Ribble Valley Borough Council
Council Offices
Church Walk,
Clitheroe
Lancashire
BB7 2RA

Phone: 0300 123 6780
Email: developeras@lancashire.gov.uk
Your ref: 3/2026/0214
Our ref: 3/2026/0214/HDC/KW
Date: 04 June 2026

Location: Land at Albany Drive Copster Green BB1 9EH
Proposal: Proposed erection of 26 affordable dwellings with associated access, gardens, parking and landscaping.
Grid Ref: 367420 433582

SCALE: 1 : 500 @ A3

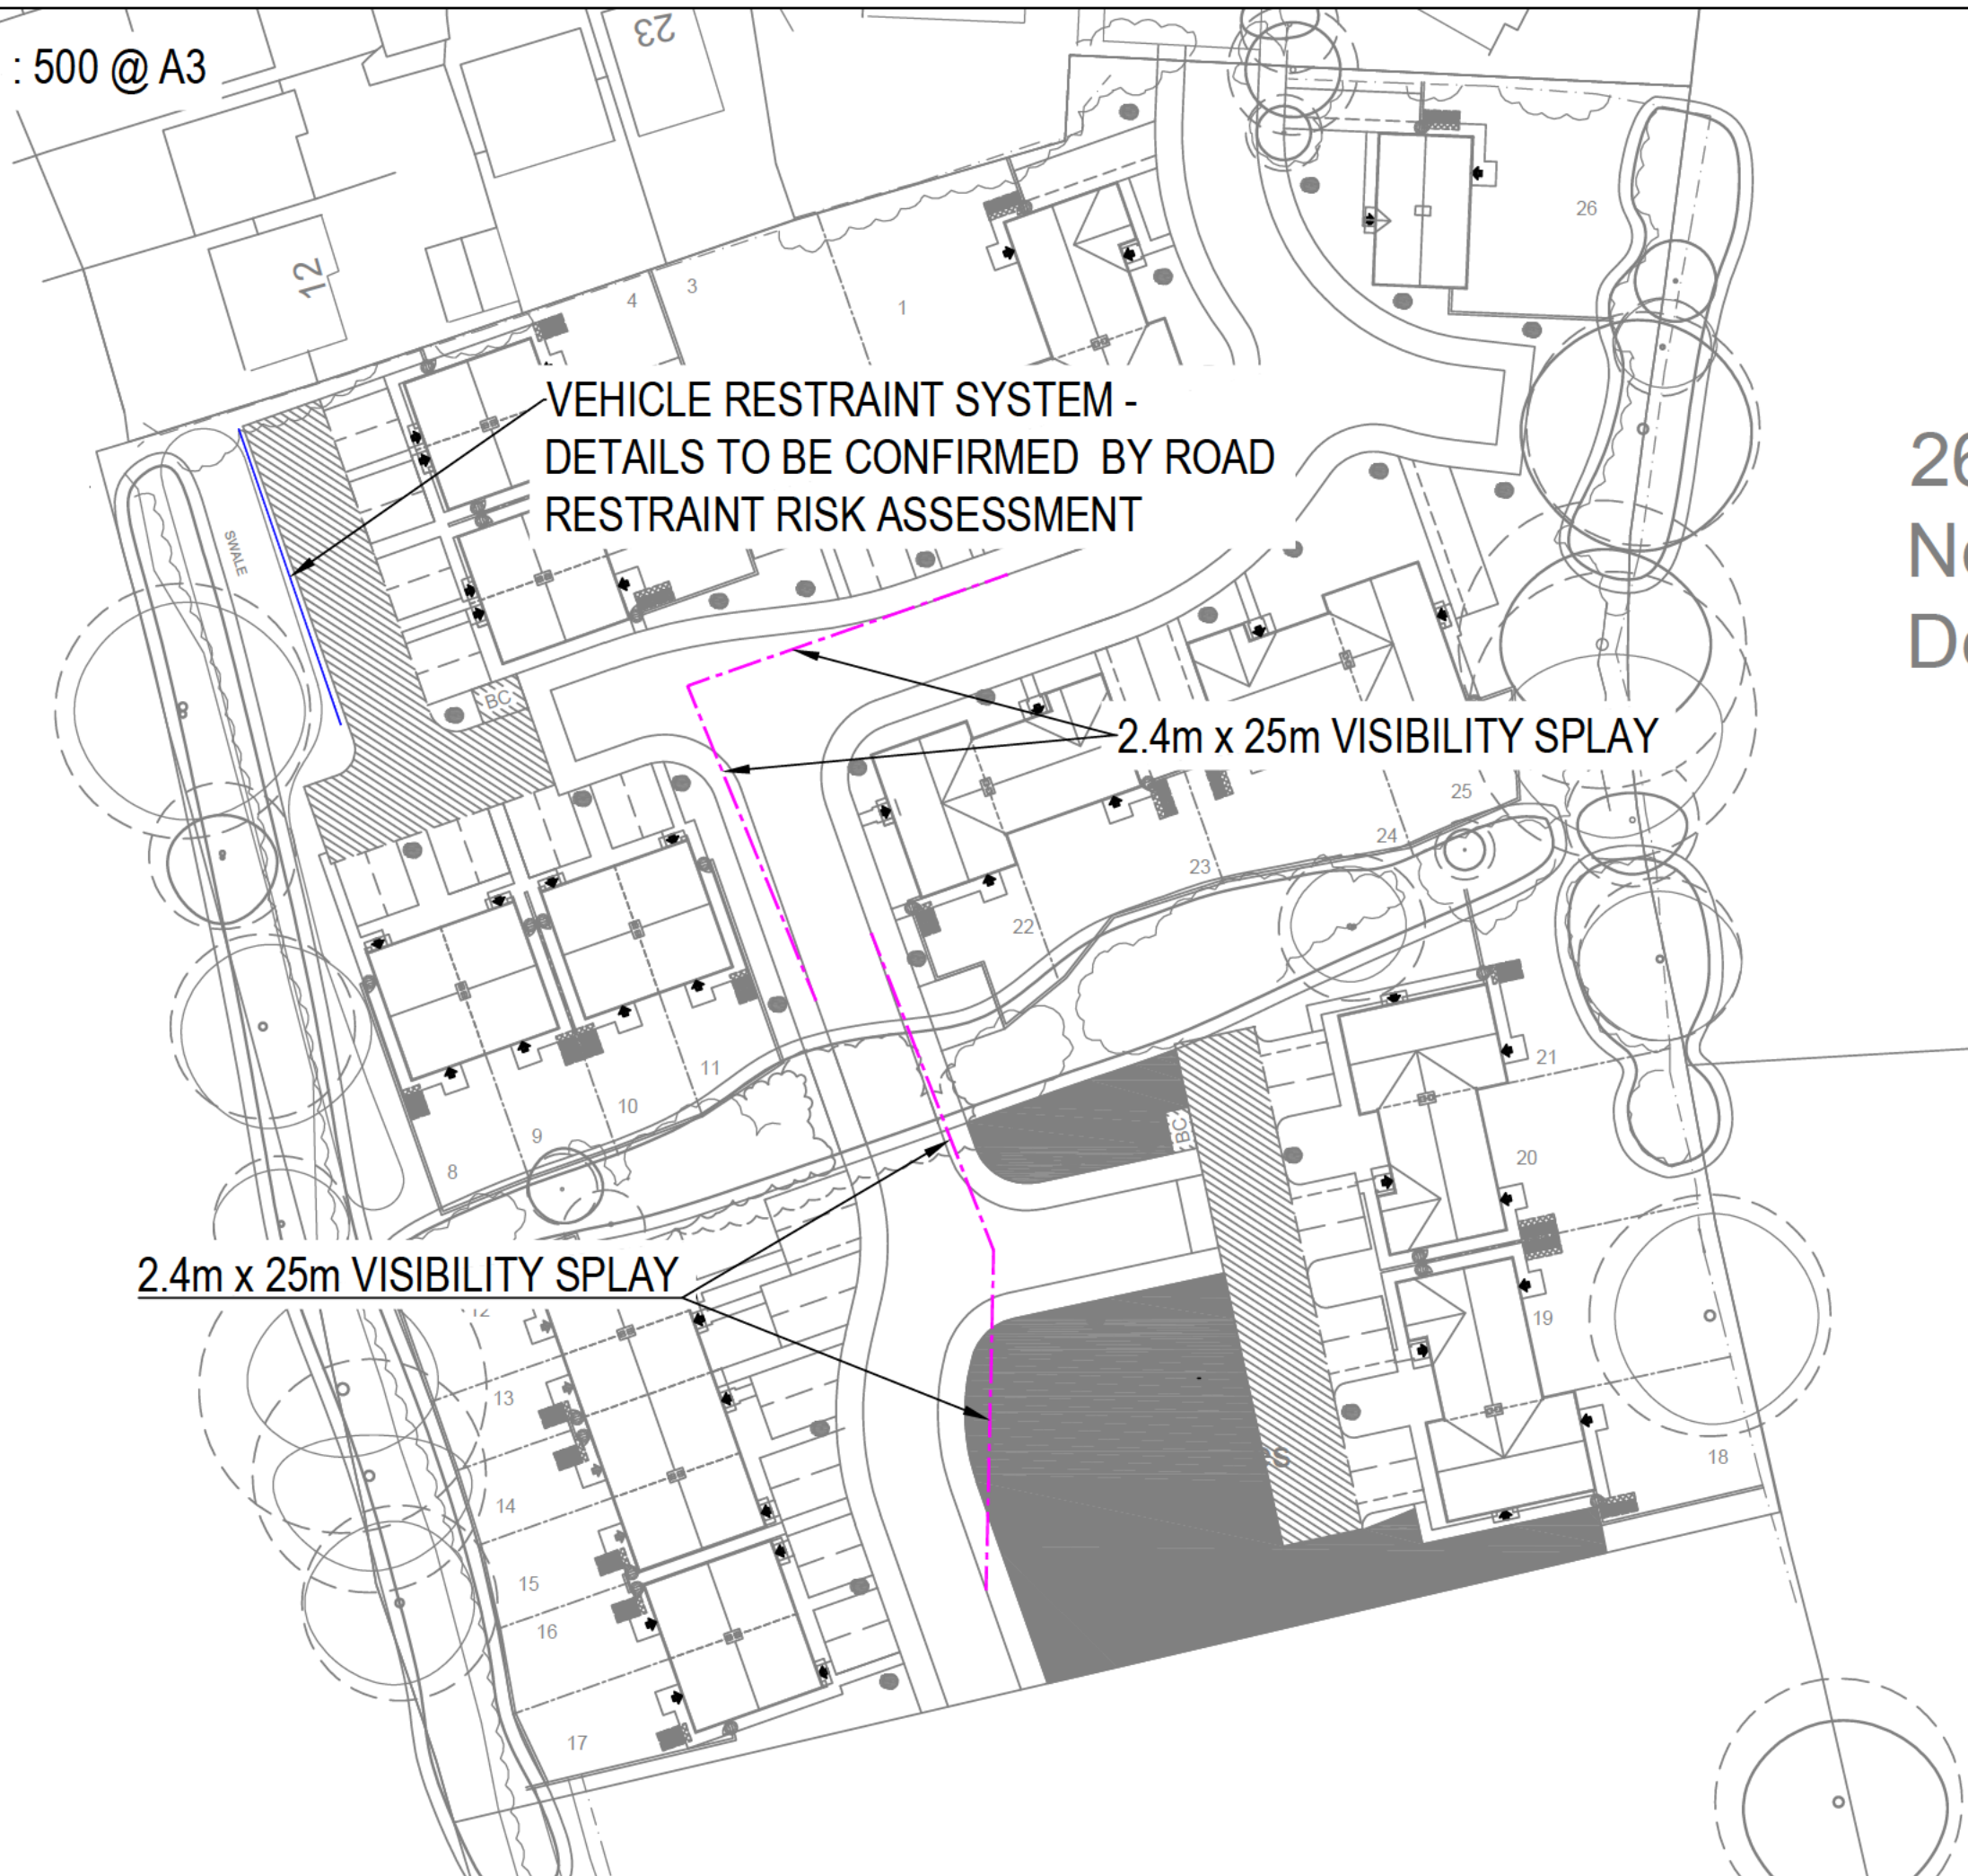
It is assumed that the primary internal carriageway will continue to serve the field and agricultural buildings to the south, where the internal road terminates it is expected to be properly boxed off as a turning head and a vehicle crossing point will be provided for access, rather than the road ending in this location.

With regard to visibility, the submitted Transport Statement indicates that appropriate visibility splays of 2.4m x 25m are achievable internally in accordance with a 20mph design speed. Drawing SCP/251150/D01 has been provided, which shows visibility at two junctions along the primary internal carriageway. At the junction serving dwellings No. 18 - 21, the visibility splay to the south has two trees which appear to fall within the splay envelope; these must be removed.

The site's landscaping includes vegetation within proximity to private driveway access arrangements throughout the site, which impact sightlines. Examples of these obstructions can be located at No. 11, 13, 18 and 25. Further consideration must be given to junctions with private drives, where intervisibility must not be compromised. Nothing is to be erected, retained, or allowed to grow within the visibility splay that exceeds 0.9 metres in height above the nearside carriageway level.

- Traffic Survey, including traffic speeds and volumes on Lovely Hall Lane.
- Resubmission of visibility details and amendments to ensure vegetation and boundary treatments do not obstruct visibility splays at a junction off the primary internal carriageway, as well as a number of private driveways across the site
- Provision of improved pedestrian access alongside parking areas, ensuring sufficient width (typically 5.7–6.0 m for two vehicles and pedestrian movement) and avoiding reliance on neighbouring driveways.
- Clarification of the southern extent of the access road, including provision of a suitable turning head and defined access arrangement for agricultural land.
- Provision of Vehicle Restraint Systems (VRS) adjacent to drainage features where required to ensure safety.
- An review of the red edge boundary, amendments should be made to ensure it meets the adopted highway line.
